# CITY OF ALBUQUERQUE

July 19, 2021

**Re: US Electrical Corporation**  
**314 Arizona St SE**  
**Traffic Circulation Layout**  
Architect's Stamp 06-09-2021 (K18-D092A)

ADA STANDARDS
A1.1 1/4" = 1'-0"

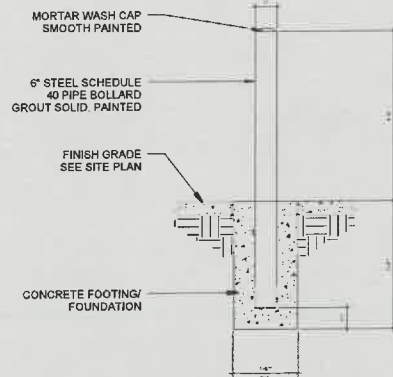
8. Label the compact parking spaces by placing the words "COMPACT" on the pavement of each space.
9. ADA curb ramps must be updated to current standards and have truncated domes installed at the corner of Acoma/Arizona.

BIKE RACK DETAIL
A1.1 NTS

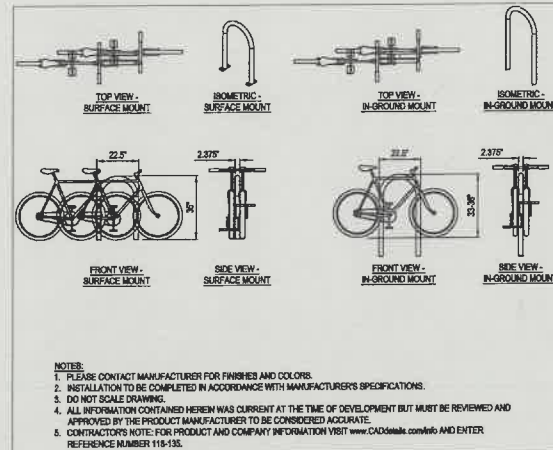
12. All bicycle racks shall be designed according to the following guidelines:
  - a. The rack shall be a minimum 30 inches tall and 18 inches wide.
  - b. The bicycle frame shall be supported horizontally at two or more places. Comb/toaster racks are not allowed.

- c. The rack shall be designed to support the bicycle in an upright position. See the IDO for additional information.
  - d. The rack allows varying bicycle frame sizes and styles to be attached.

- e. The user is not required to lift the bicycle onto the bicycle rack.
  - f. Each bicycle parking space is accessible without moving another bicycle.

13. Bicycle racks shall be sturdy and anchored to a concrete pad.
14. A 1-foot clear zone around the bicycle parking stall shall be provided.
15. Bicycle parking spaces shall be at least 6 feet long and 2 feet wide.

SITE PLAN
A1.1 1" = 20'-0"

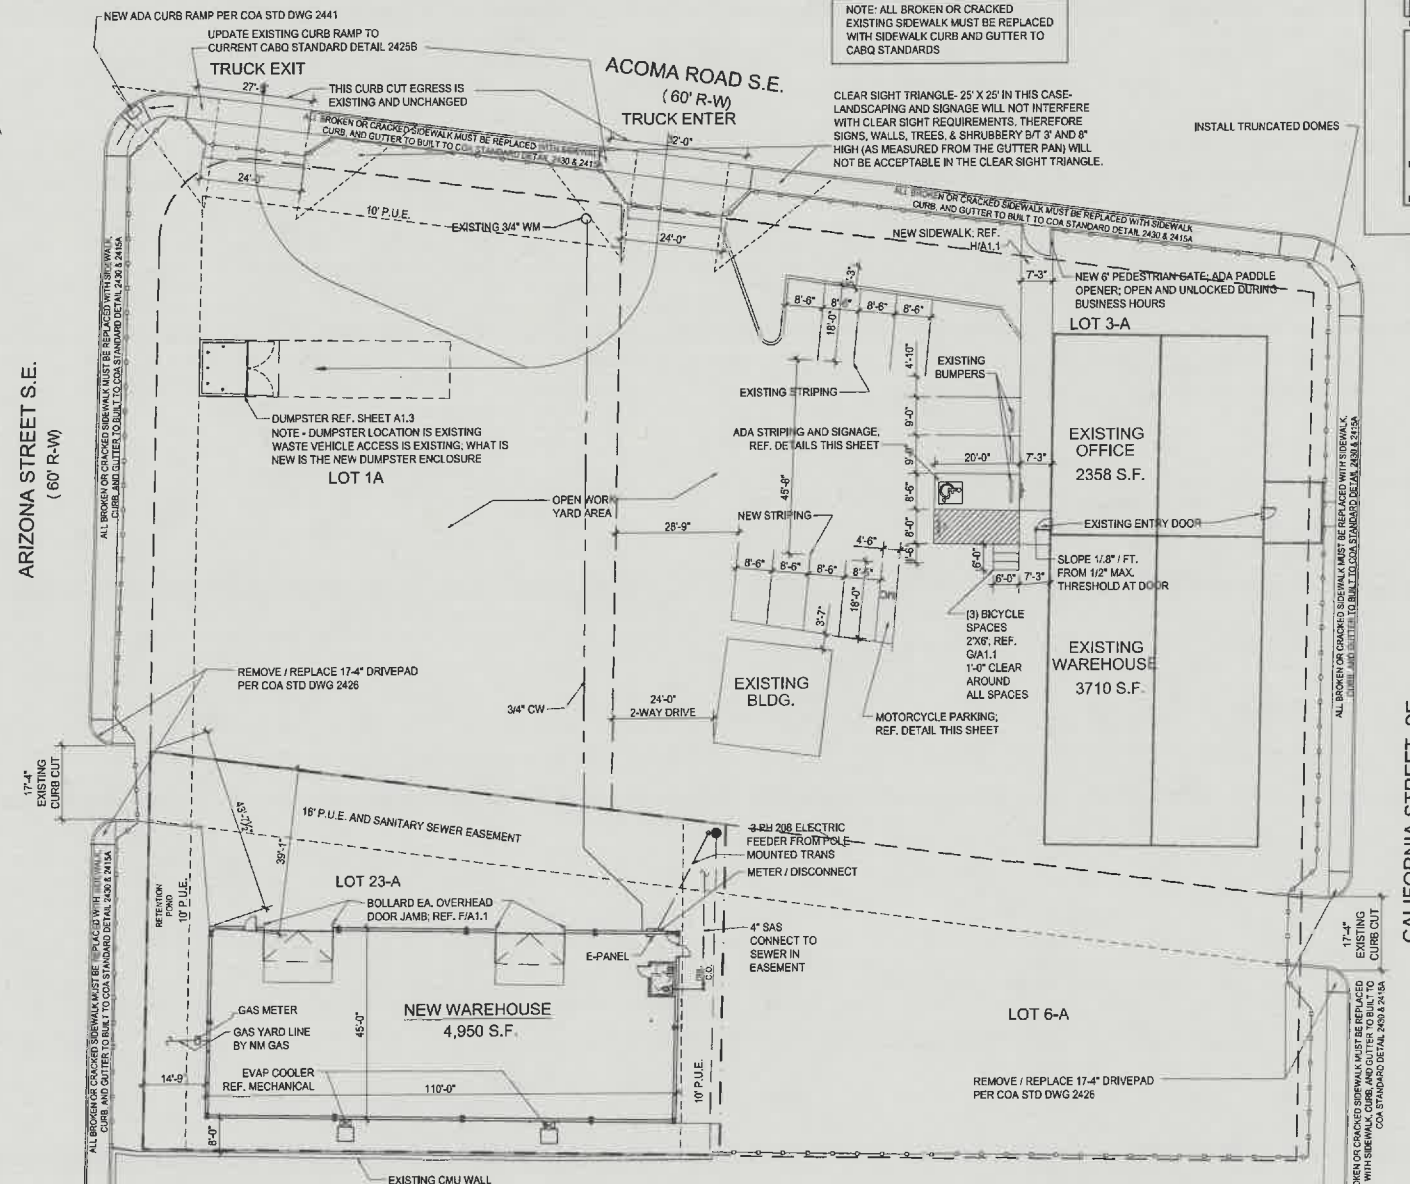
1. Please show a vicinity map showing the location of the development in relation to streets and well known landmarks.
2. List the number of parking spaces required by the IDO as well as the proposed number of parking spaces including bicycle and motorcycle parking and coordinate/discuss with Zoning.
3. Please identify all existing buildings, doors, structures, sidewalks, curbs, drive pads, wall and anything that influences the parking and circulation on the site.
4. Identify all existing access easements and rights of way width dimensions(IF APPLICABLE).
5. Maximum access width for arterial, collector, and local streets are as follows:

6. Please list the width and length for all existing and proposed parking spaces. Some dimensions are not shown.
7. **The minimum parking stall dimensions are:**

10. All existing drivepads fronting Acoma and Arizona must be updated to current standards. Verify the ADA access across these entrance driveways.
11. Motorcycle parking space: Label pavement MC.

16. Show all **drive aisle widths** and radii. Some dimensions are not shown.
17. The minimum drive aisle dimensions are shown below

18. Per the IDO, a 6 ft. wide ADA accessible pedestrian pathway is required from the public sidewalk to the building entrances. **Please clearly show this pathway and provide details.**
19. Per DPM, a 6 ft. wide ADA accessible pedestrian pathway is required from the ADA parking stall access aisles to the building entrances. **Please clearly show this pathway and provide details.**

20. All sidewalks along public streets:
  - **Sidewalk are required and should be placed at the property line.**
21. Curbing should be installed to delineate landscape, parking, and pedestrian ways and identify points of access. Please call out detail and location of barrier curb.

22. Parking areas shall have barriers to prevent vehicles from extending over public sidewalk, public right-of-way, or abutting lots.
23. Provide a copy of refuse approval.

24. Please provide a sight distance exhibit
25. Show the clear sight triangle and add the following note to the plan: "Landscaping and signage will not interfere with clear sight requirements. Therefore, signs, walls, trees, and shrubbery between 3 and 8 feet tall (as measured from the gutter pan) will not be acceptable in the clear sight triangle.

28. Any private structures that are located within public right-of-way such as fences and walls shall either be removed or else a revocable permit with the City is required in which an annual fee is paid per year, based on square footage of the encroachment (Fencing shown within COA ROW).

29. Depending on site's use of an adjacent alleyway and on type of use for proposed site, alleyway improvements are required. This would include paving and/or proper right-of-way dedication to meet current width standards. Shown on plan as a 16 ft PUE and Sanitary Sewer Easement, this appears to be an existing Alley way.

30. Provide constructions for all existing and proposed infrastructure.
31. Acoma Road: Shown is a driveway that is too close to the intersection of Acoma/Arizona. Please relocate. The proposed location of driveways will need to follow DPM criteria.

32. **Arizona existing driveway:** Unused curb cuts must be replaced with sidewalk and curb & gutter. A build note must be provided referring to the appropriate City Standard drawing (2430 & 2415)
